**RE: Sundance Construction – Beverly Hills
Grading and Drainage Plan
Engineer's Stamp Date: 02/20/18
Hydrology File: B18D023**

Based upon the information provided in your resubmittal received 02/21/2018, the Grading and Drainage Plan is approved for Building Permit.

**RE: Sundance Construction -Beverly Hills
Grading and Drainage Plan
Engineer's Stamp Date: 01124/18
Hydrology File: 818D023**

This letter is in response to your comments by letter dated January 30, 2018. The comments have been addressed as follows:

C-100

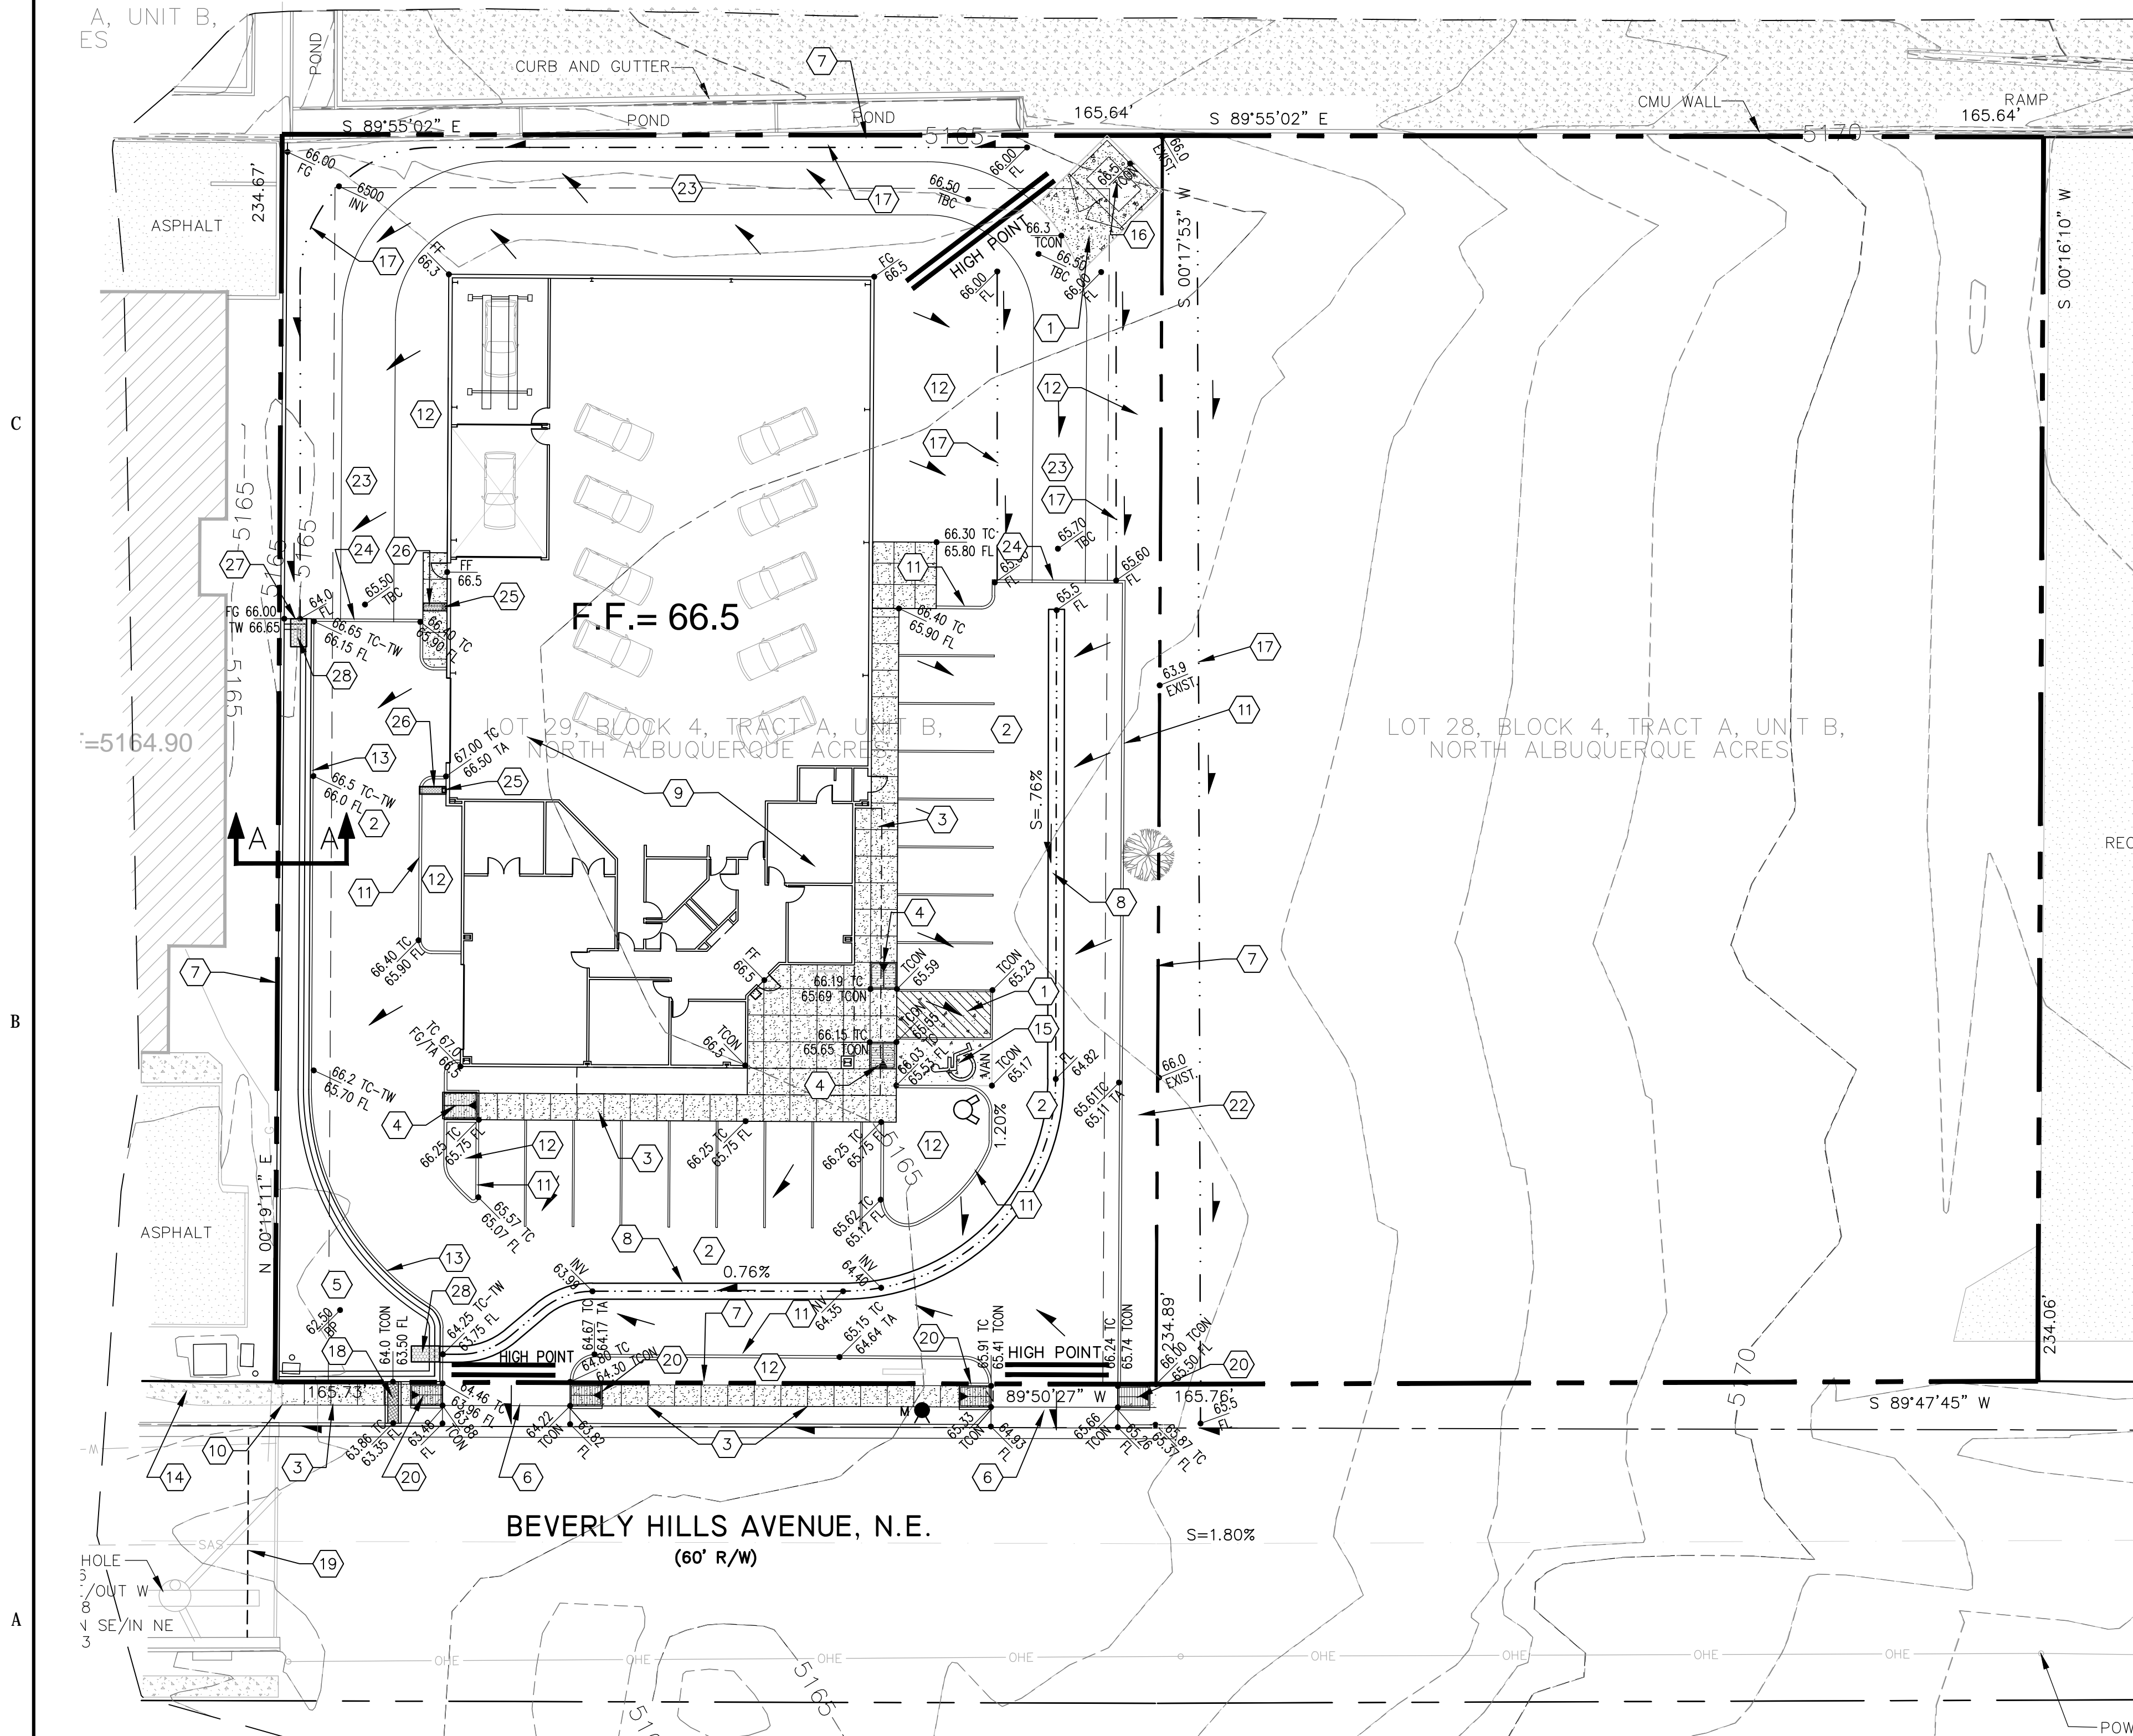
1. Please provide the weir calculations for the curb cuts.

See attached.

SECTION AA

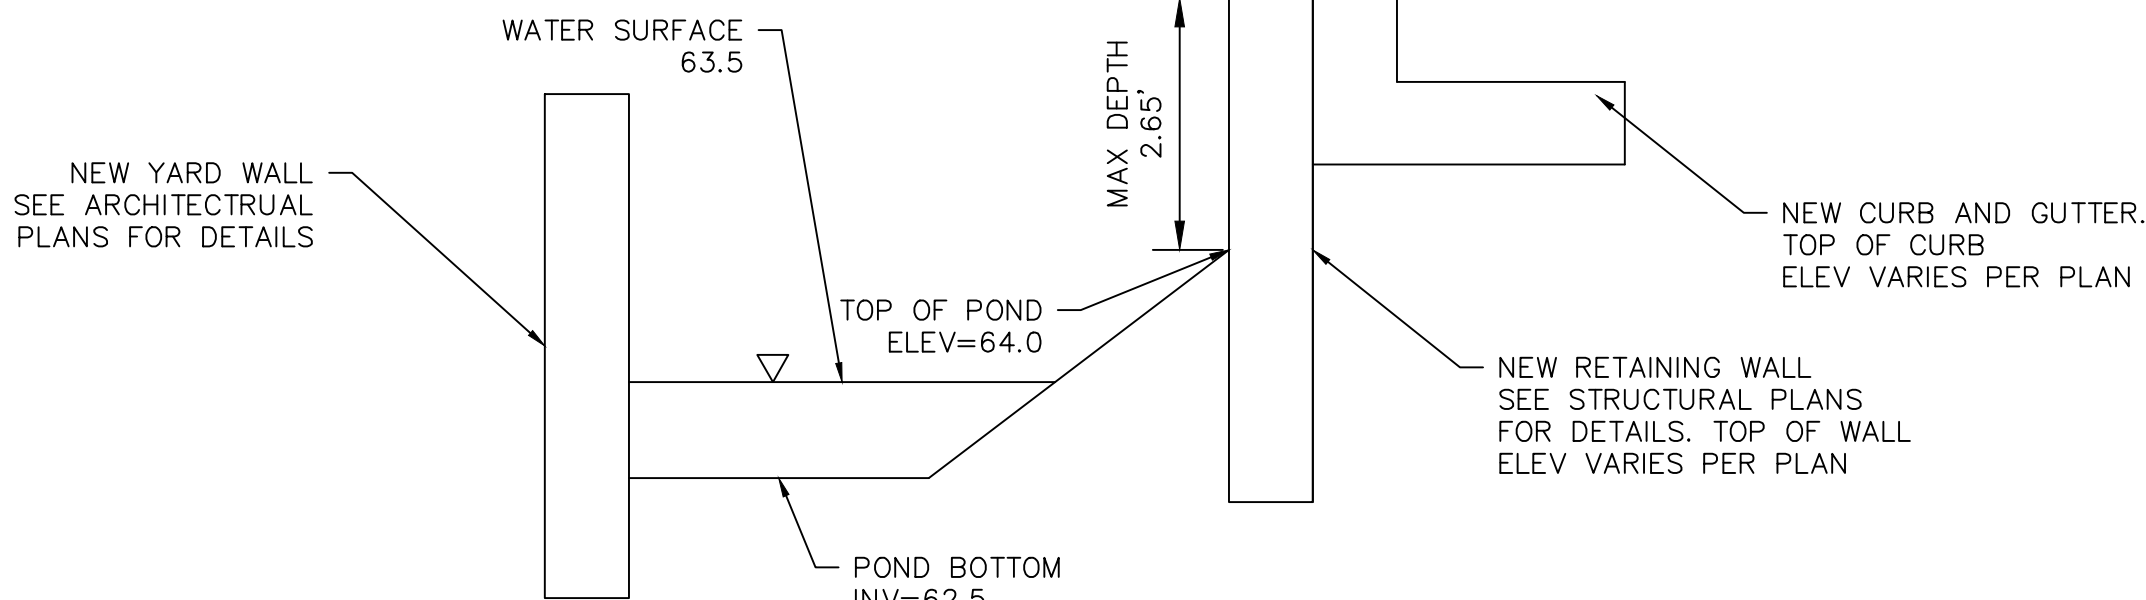
6. Section A-A. Please show the property line and dimension of the wall from the property line.

7. Section A-A. Per DPM Ch. 22.5.B, grading and construction of retaining walls at or near the property line must demonstrate that the adjacent property is not damaged or its use constrained. Any such encroachment by the wall or grading must be accompanied by written permission of both landowners. Therefore the wall may have to be moved away so that the footer does not impede the adjacent property.

See sheet C-101.

Added some notes for clarity. See sheet C-101.
